Rezoning Transportation Analysis

Petition Number: 2021-092

| Date | Description |
|------------|--------------------|
| 08-23-2021 | Second Review (KP) |

SECTION E-E PEARL PARKWAY

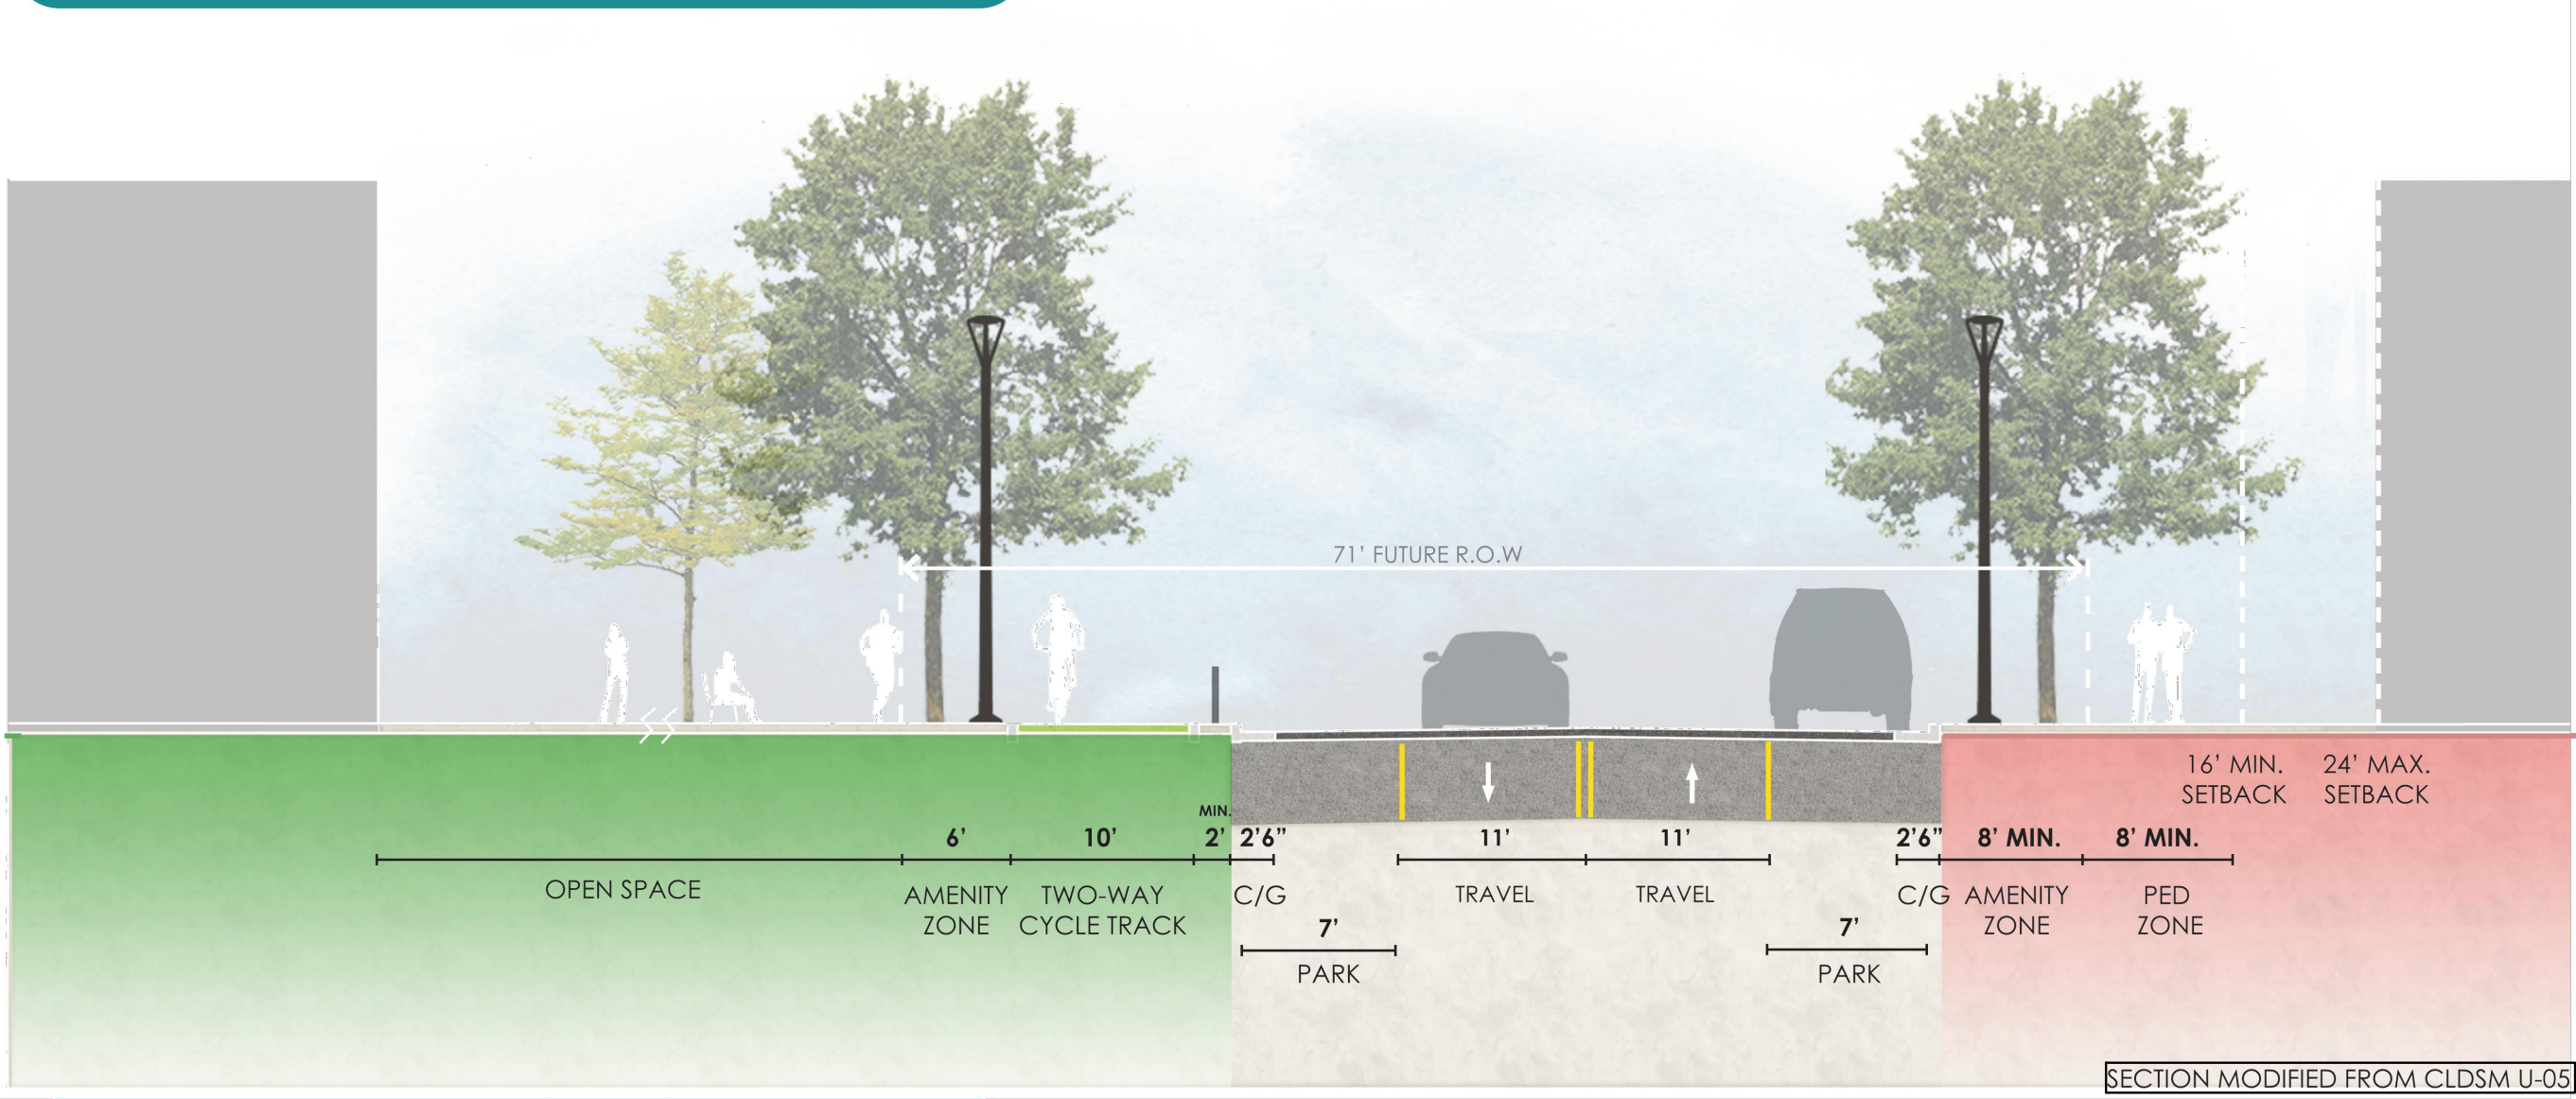
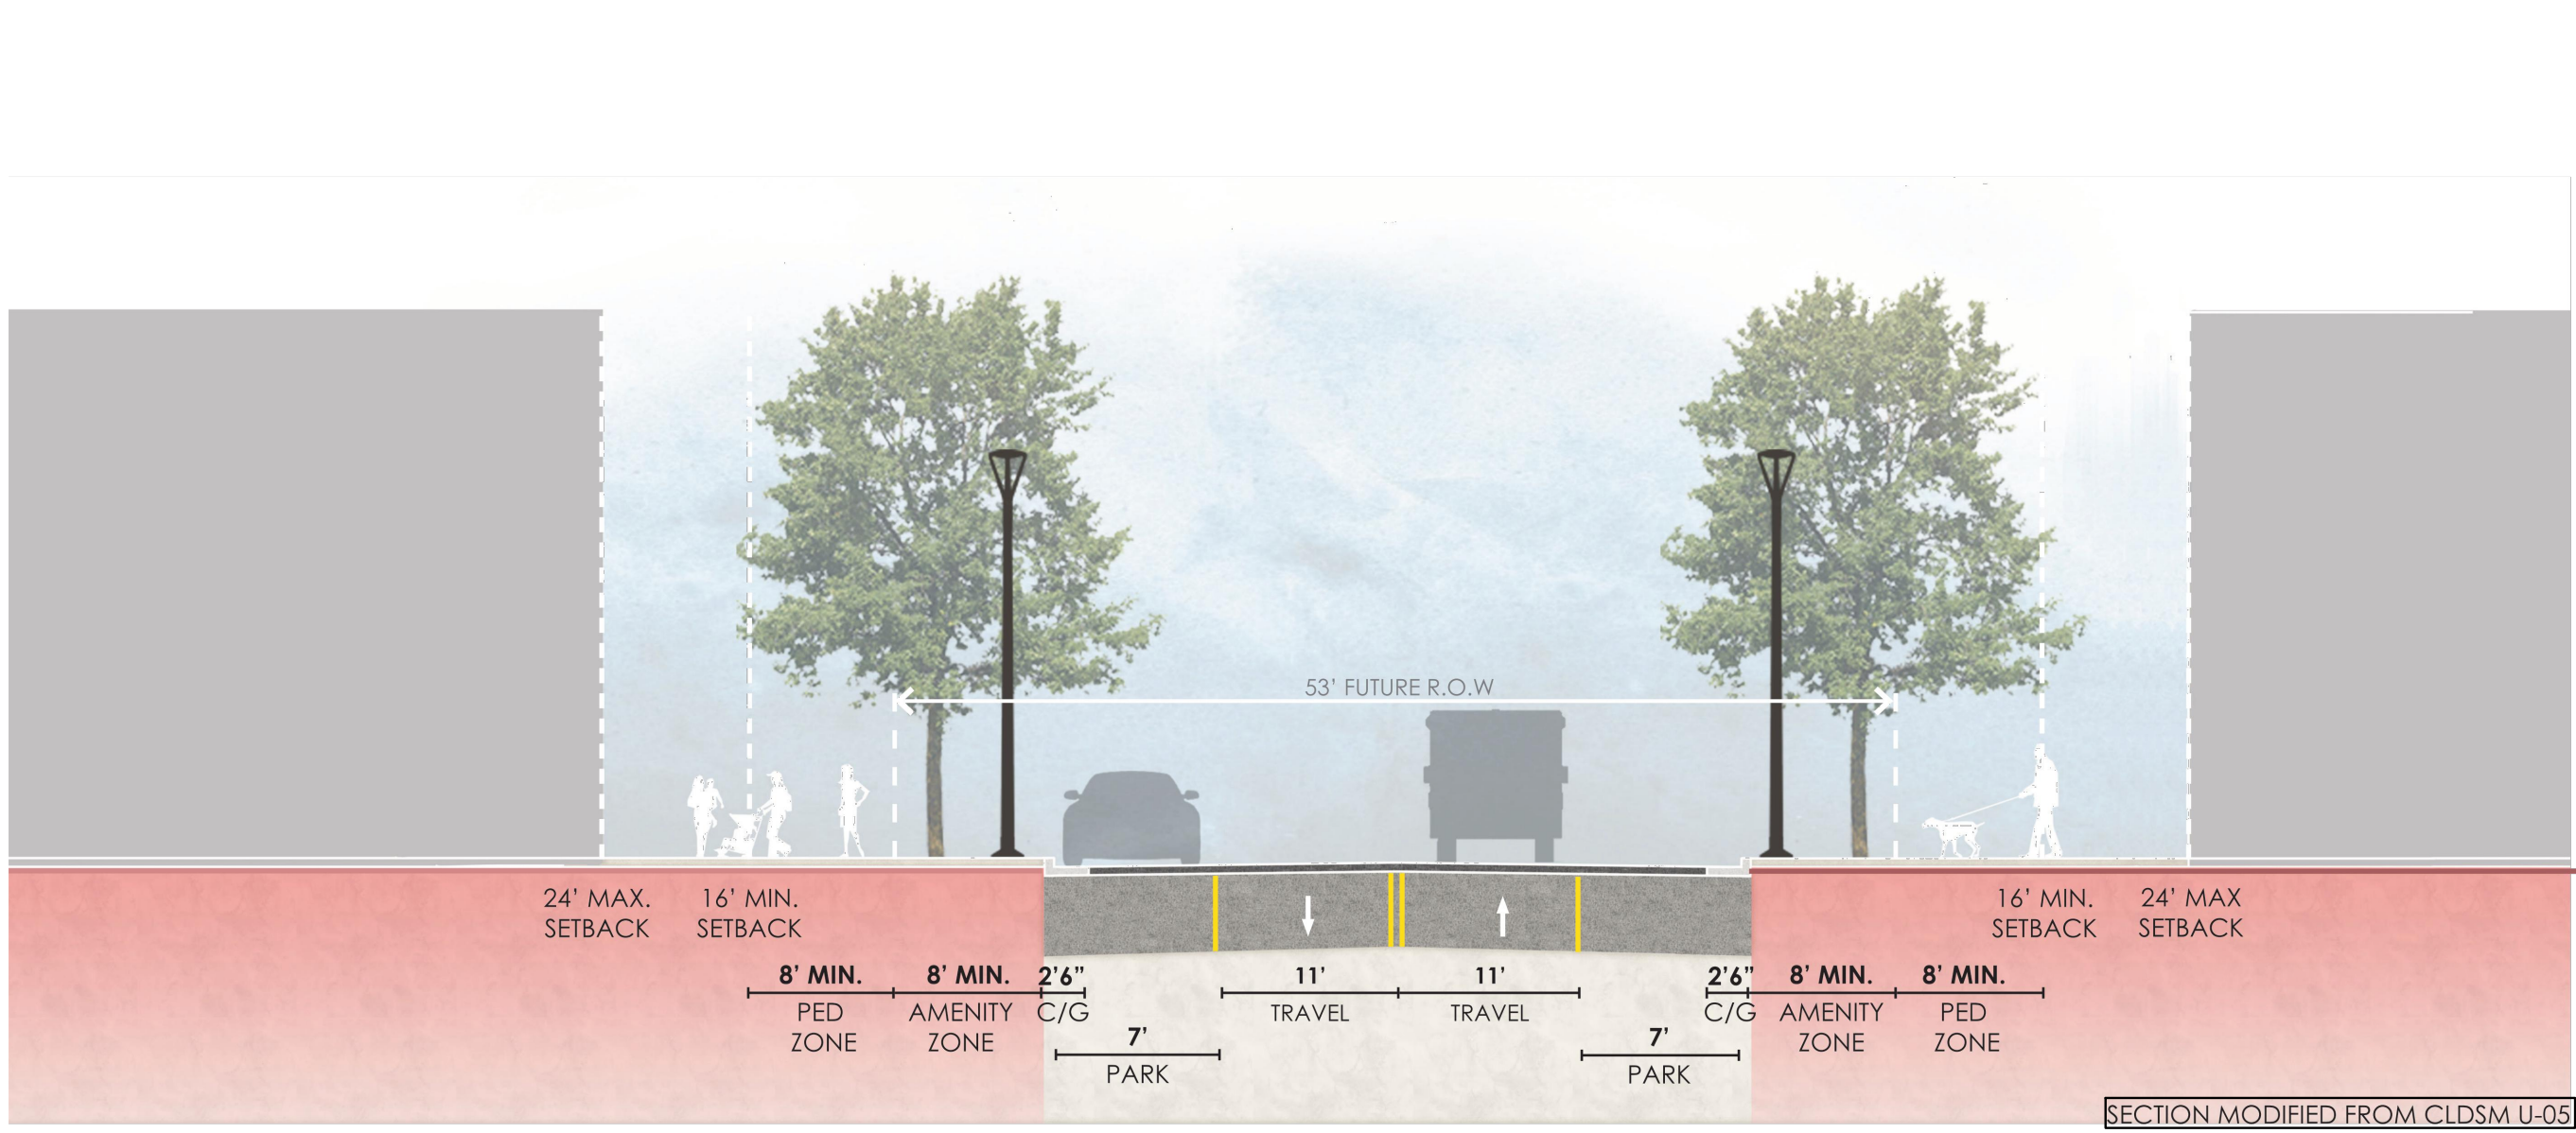
The proposed and existing back of curb location on Morehead Street must be labeled dimensioned from the existing centerline.

The proposed and existing Morehead Street right-of-way dedication must be labeled dimensioned from the existing centerline.
